Your Ref: OWPC16526
Our Ref: FP/268/17/PL 26-10-2017
Please ask for:
Richard Temple

Detached 9No. bedroom annexe for Beachcroft Hotel with 9No. car parking spaces.
Boat Pound between Greenock Villa & The Gunpoint Clyde Road Felpham

Thank you for your internet representation made on 8th December 2017 which has been recorded as '**an objection**' with the comments as follows:

PROJECT Gull Point Suites - On the Beach
TITLE Typical Sections
SCALE 1 : 100
DATE 20/09/17
DRG NO IBA/480/09
REVISIONS

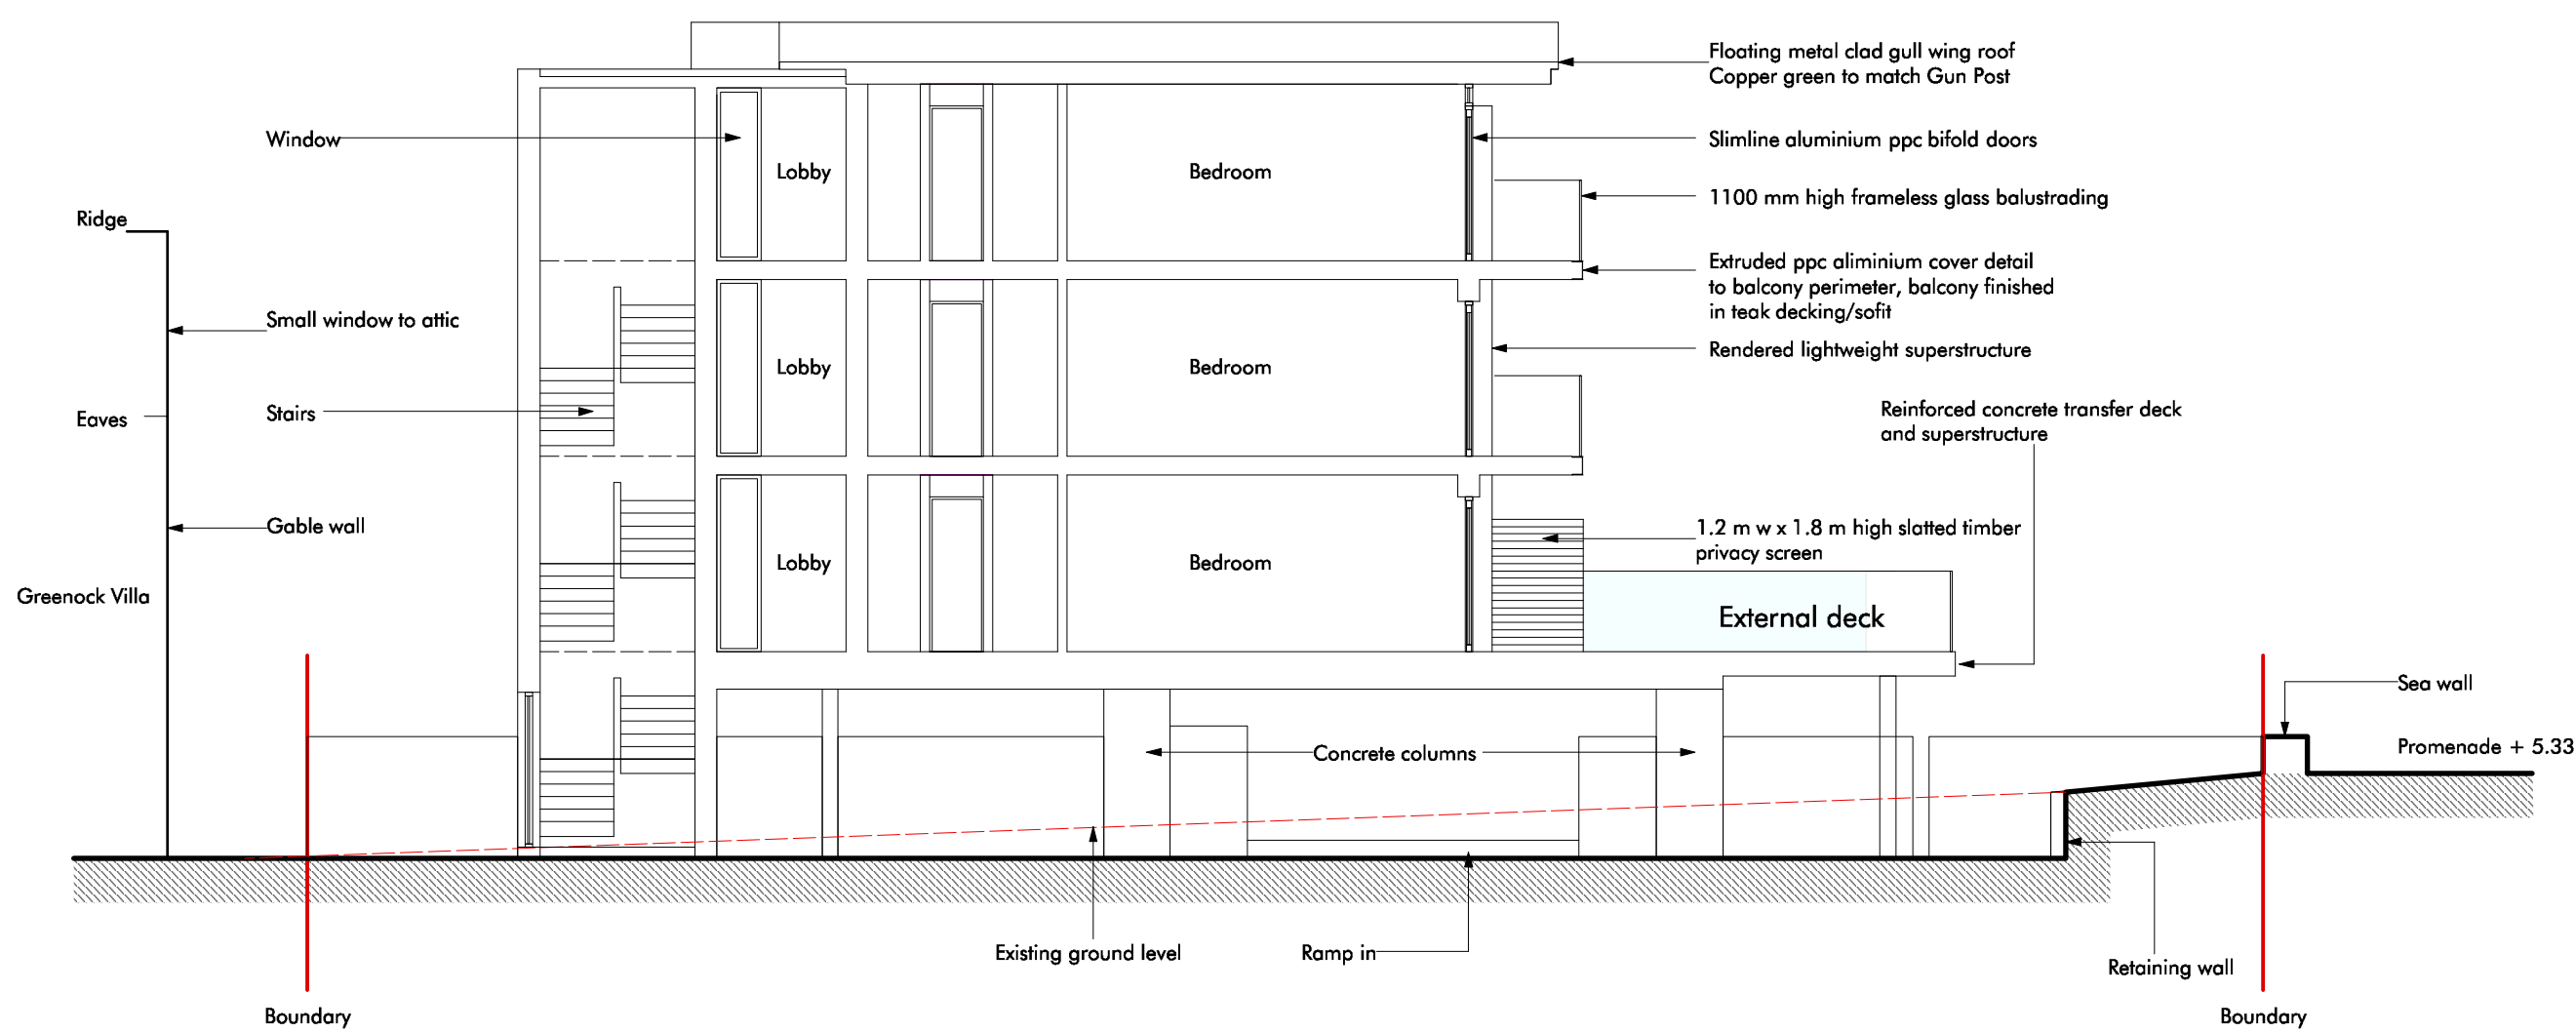
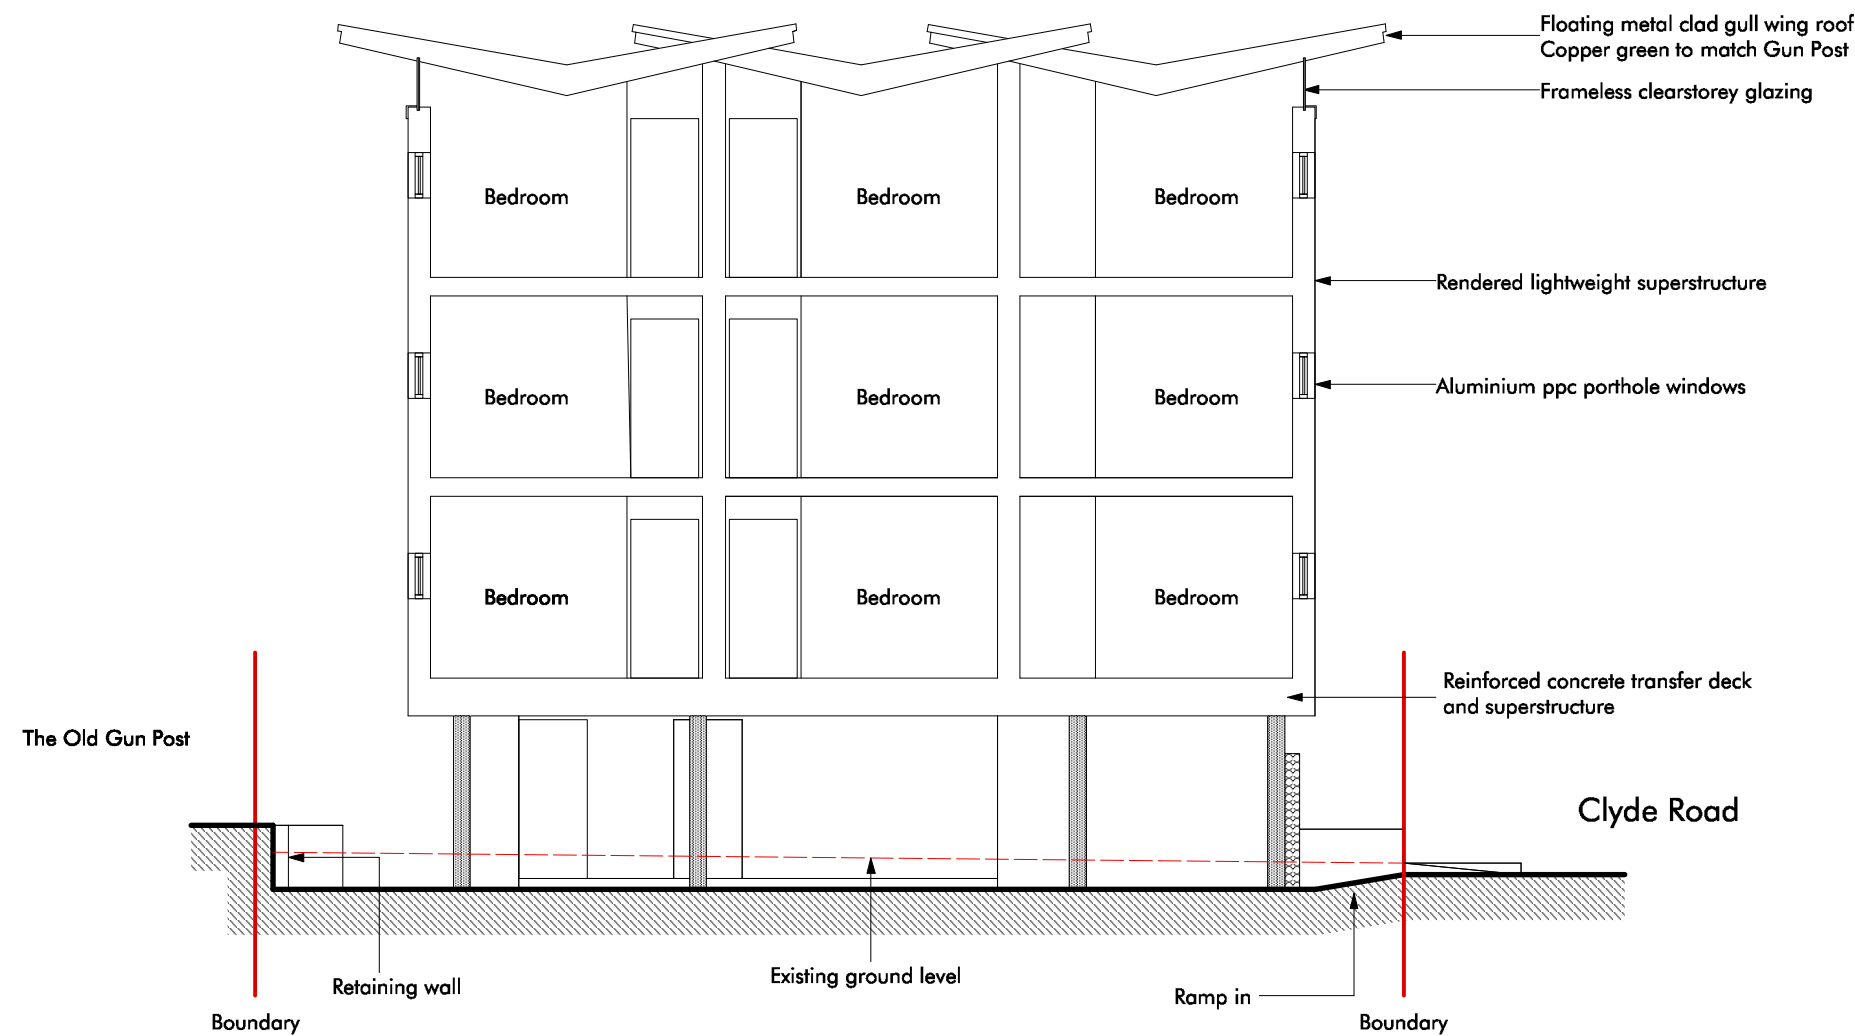
I am very concerned about the height of this development. It will over shadow the Victorian and Edwardian houses behind it. These are some of the oldest buildings in the area. They form the character of this part of West Sussex. Perhaps take it down a level.
